**From:** Matthew Bender <mbender@gcal.com.au>  
**Sent:** Monday, 10 December 2018 9:32 AM  
**To:** Aditi Coomar <Aditi.Coomar@planning.nsw.gov.au>  
**Cc:** Brett Curtis <bcurtis@gcal.com.au>; Ian Rigby <irigby@bigpond.net.au>  
**Subject:** RE: YBCG-MA-001 - Dev, Tweed Valley Hospital (SSD 9575) [SEC=UNCLASSIFIED]

Please consider the below comments and requests in relation to the Tweed Valley Hospital development. I note that at the time of this email you are awaiting aviation specific feedback from Airservices Australia and Gold Coast Airport will require review and comment of any information provided by that authority.

Rose of Wind direction versus Wind speed in km/h (01 Oct 1987 to 10 Aug 2018)

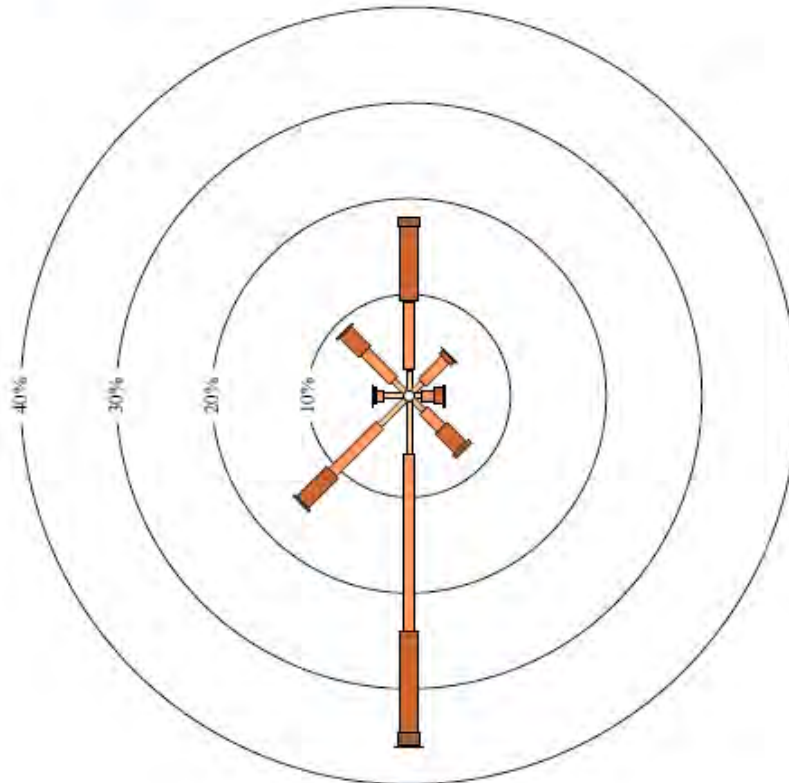
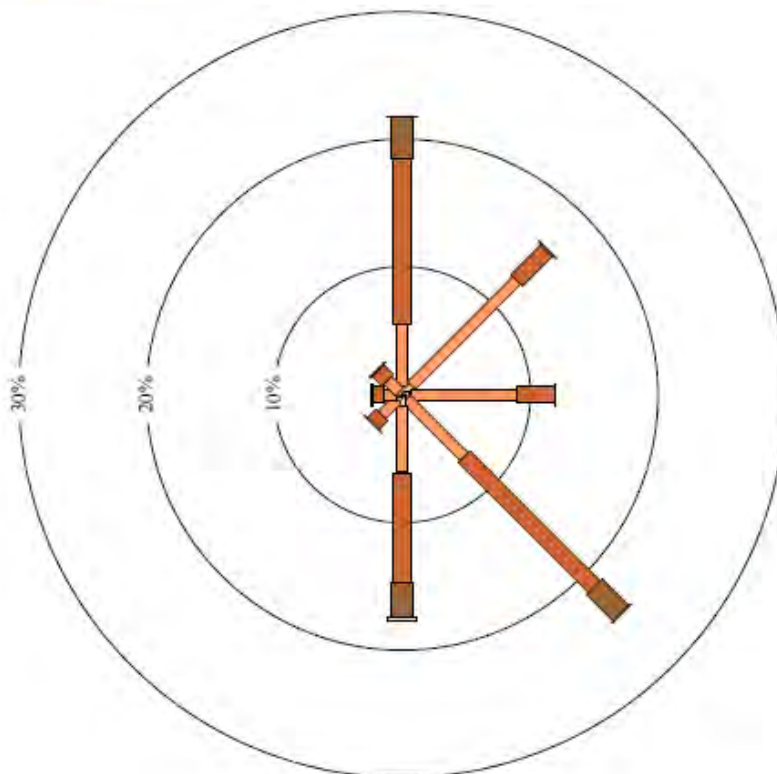
- **PP6 Wind:** Although BOM may not produce specific wind rose data for Gold Coast there are a number of platforms with available data that could be extrapolated and reviewed.
